Please upload onto Ocella the email below which is the revised consultation response from **ADC Drainage Engineers** to discharge of condition application **BE/21/20/DOC** – Salt Box.

Engineers comments in respect to surface water drainage;

APPLICATION NO: BE/21/20/DOC

Site Address: Land At Salt Box West Of Shripney Road Bognor Regis PO22 9NW

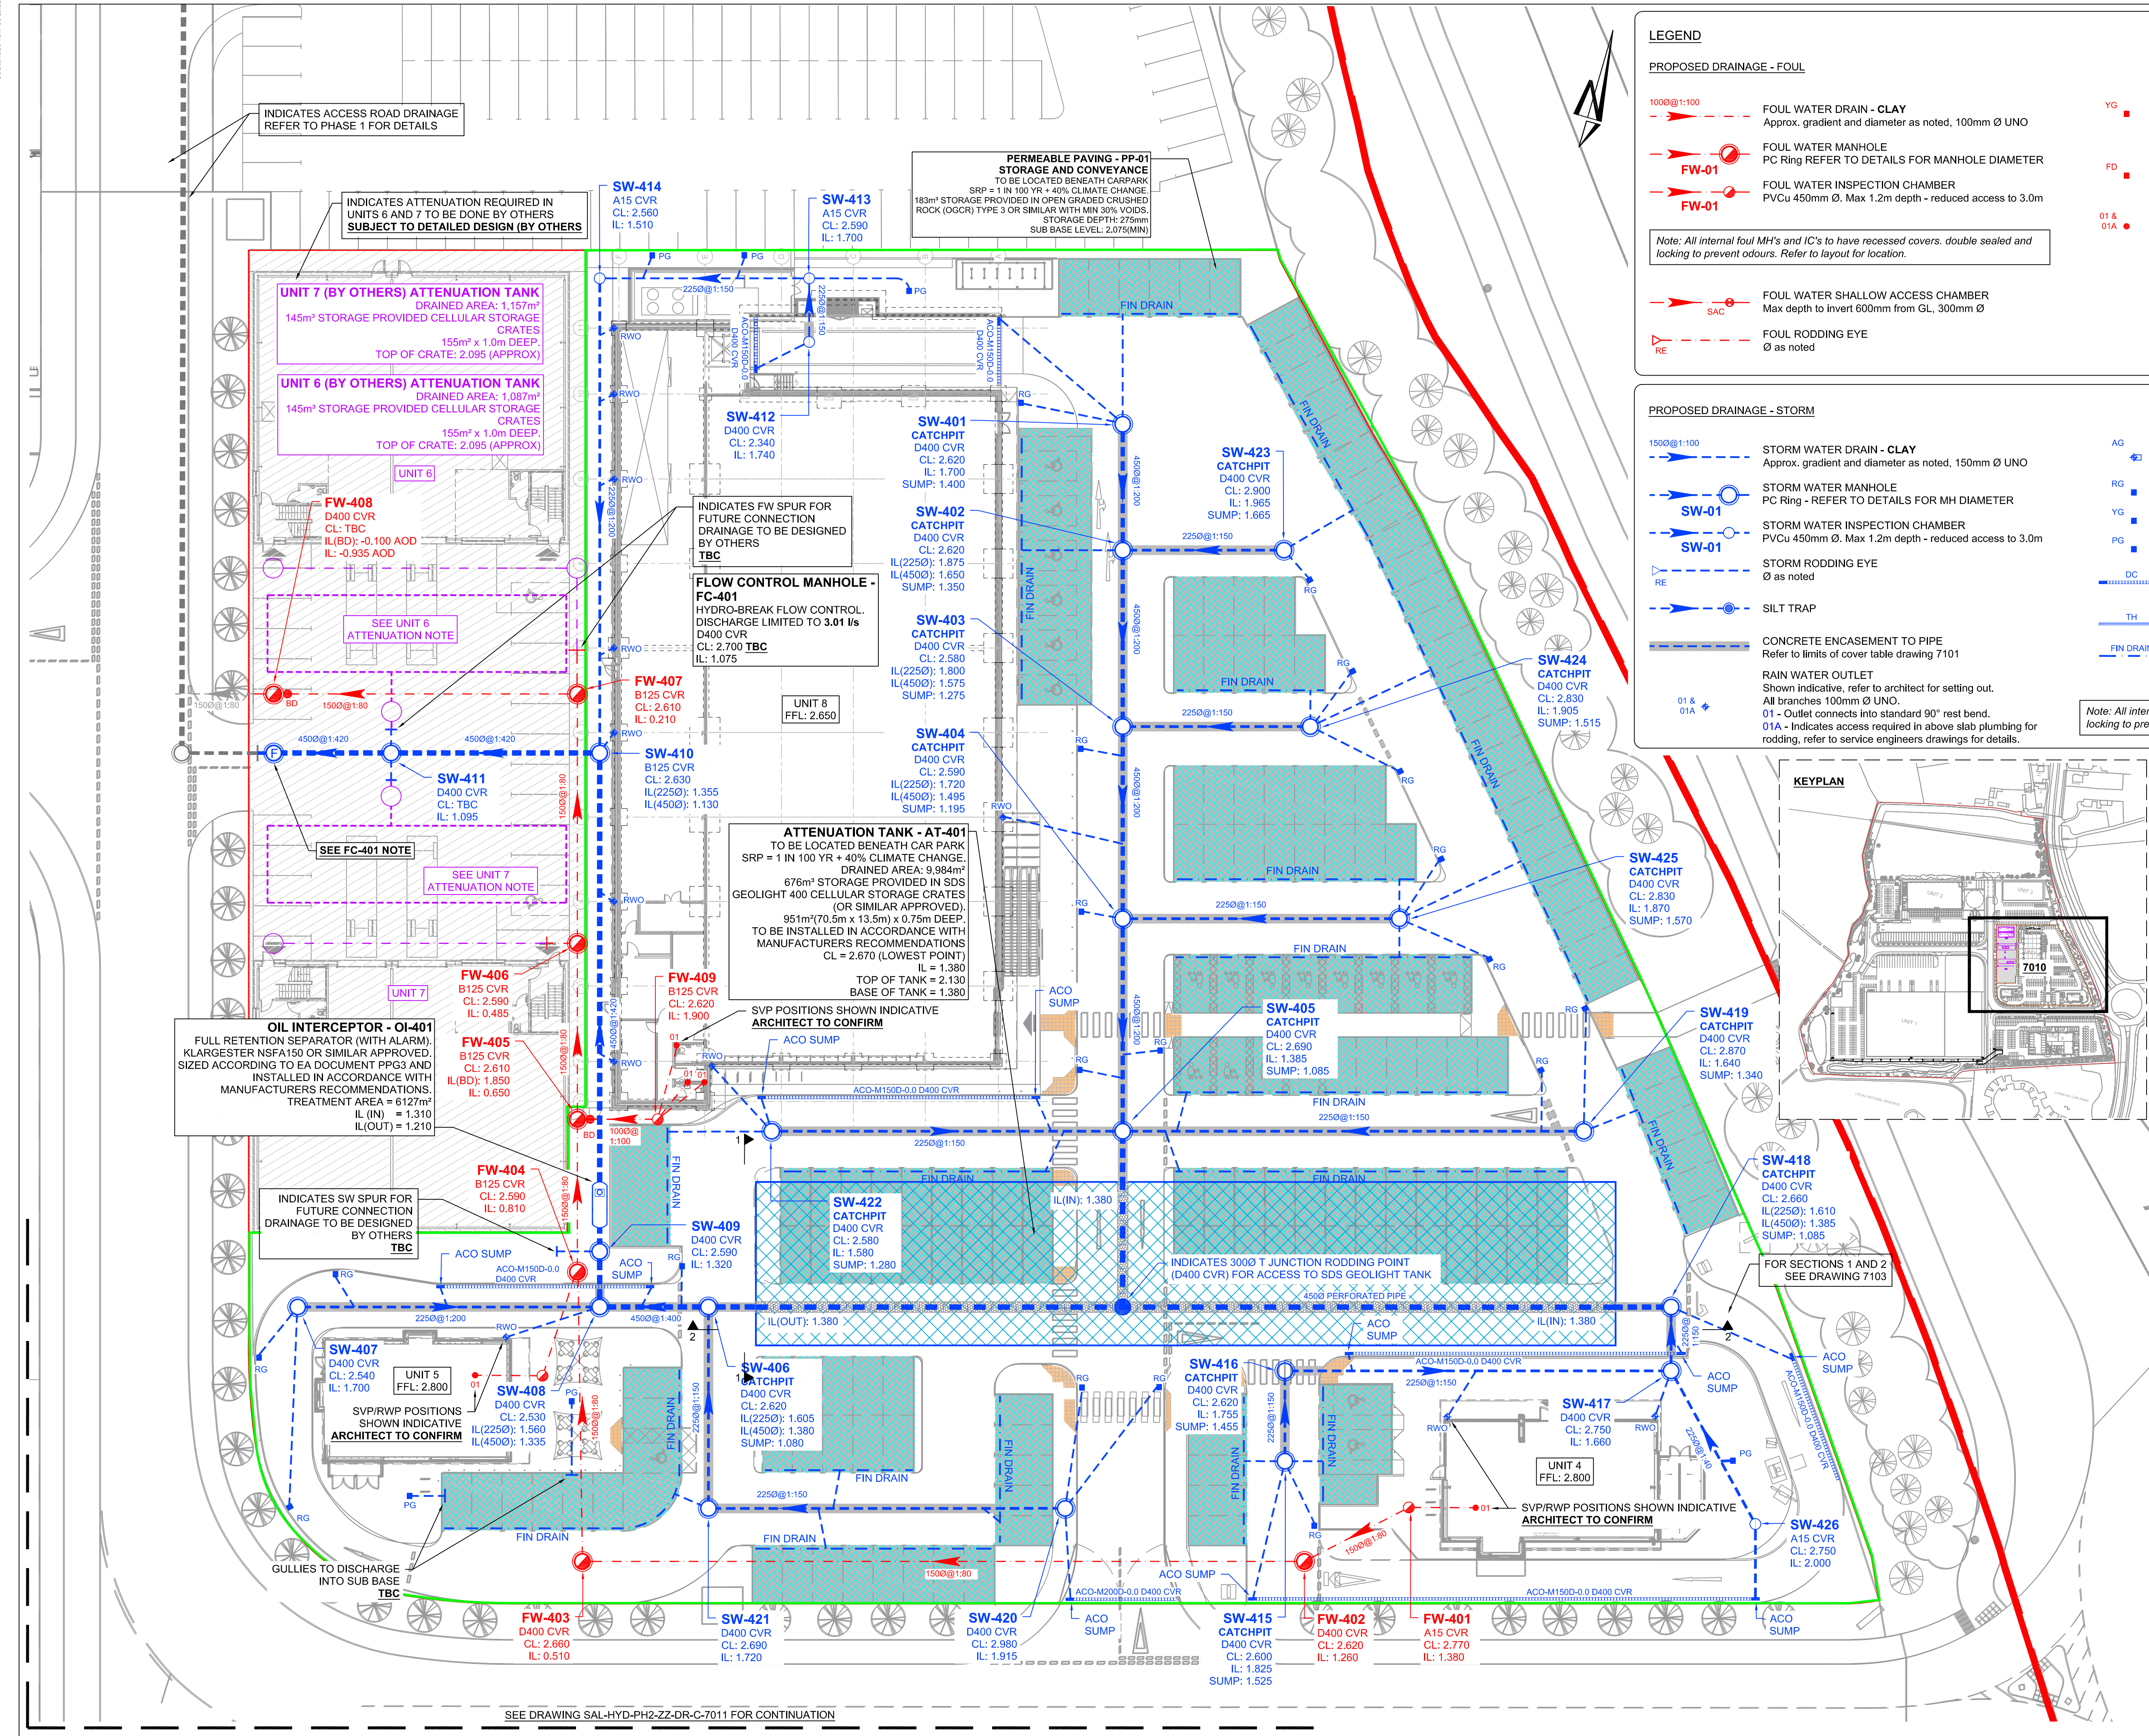
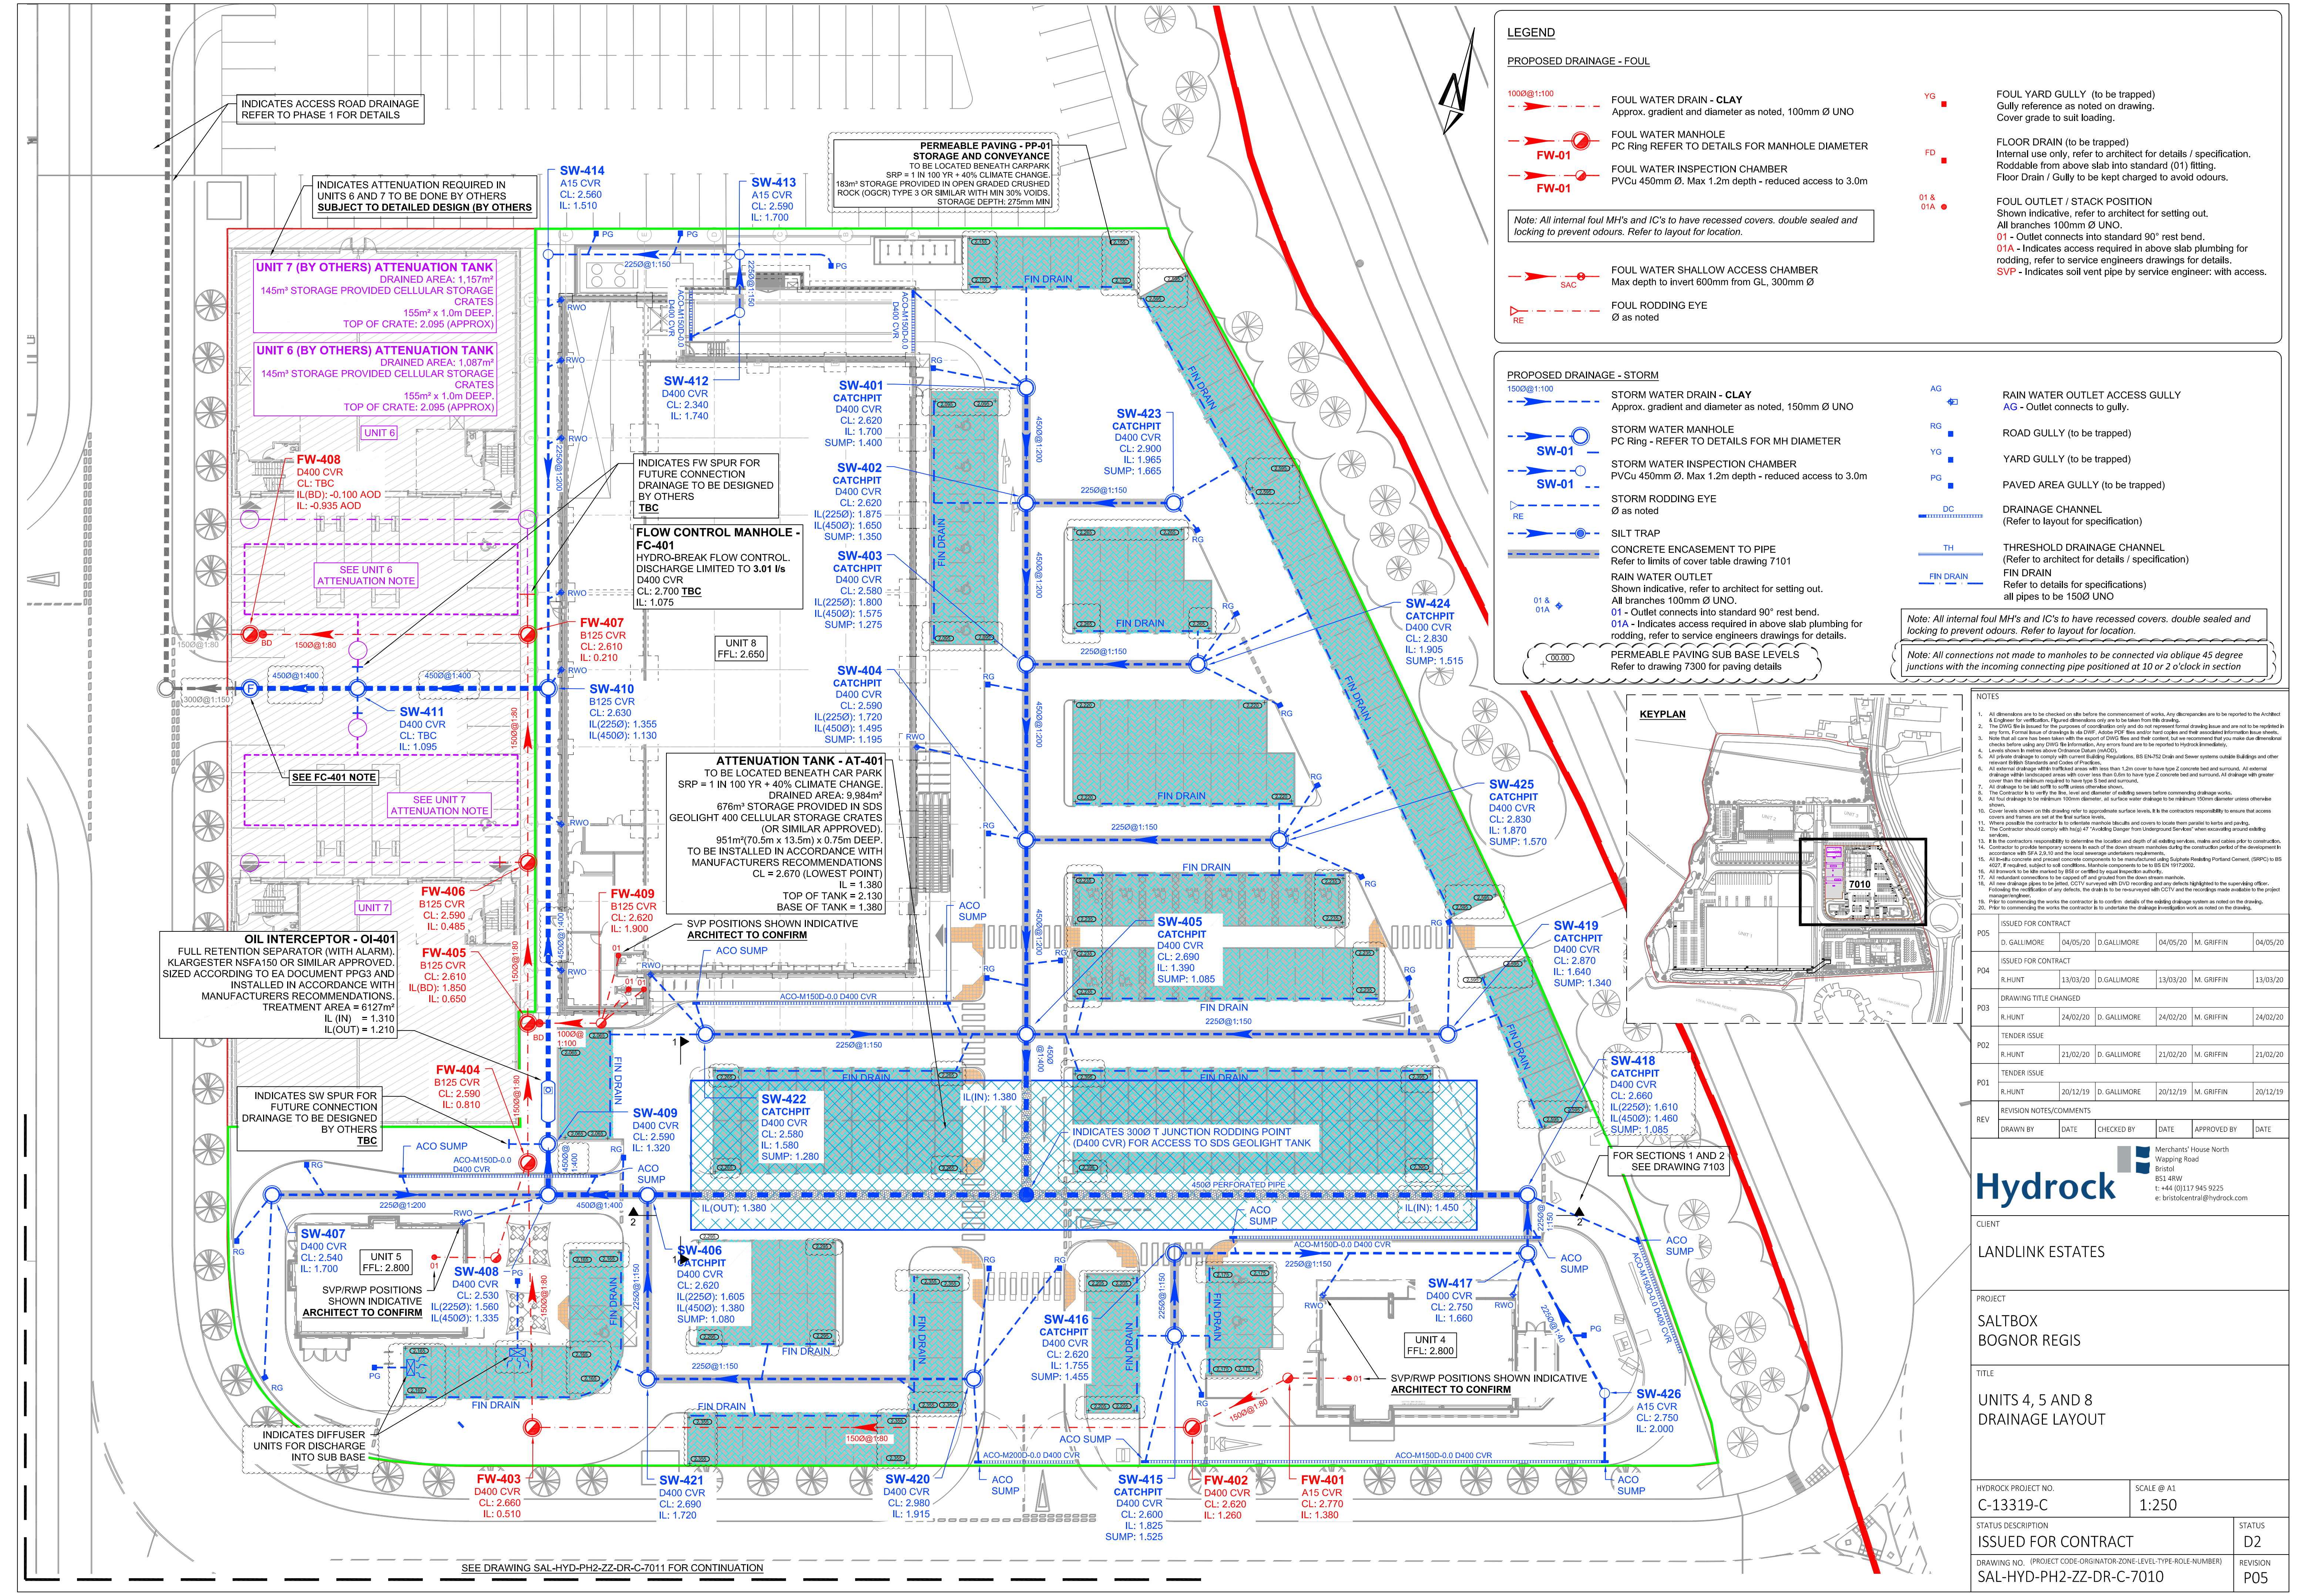
11. Specify gradient and pipe diameter (FC-401 to SW-1000) on drawings 7010 and 7021.
Pipe gradient added ok
12. Provide PG paved area gully construction detail (to incorporate silt trap).
PG detail added ok

14. Drawing 7010 – specify sub base levels for ALL permeable paving areas. On drawing 7300 – add note to refer to sub base levels on drawing 7010.
Sub base levels added To 7010 and note added to 7300. ok

15. Drawing 7010 - SW-405 to tank – specify pipe diameter and a reasonable gradient.
Gradient added ok
16. Drawing 7103 (Phase 2)– Section 2-2 – should this be labelled AT-401?
401 label added. ok
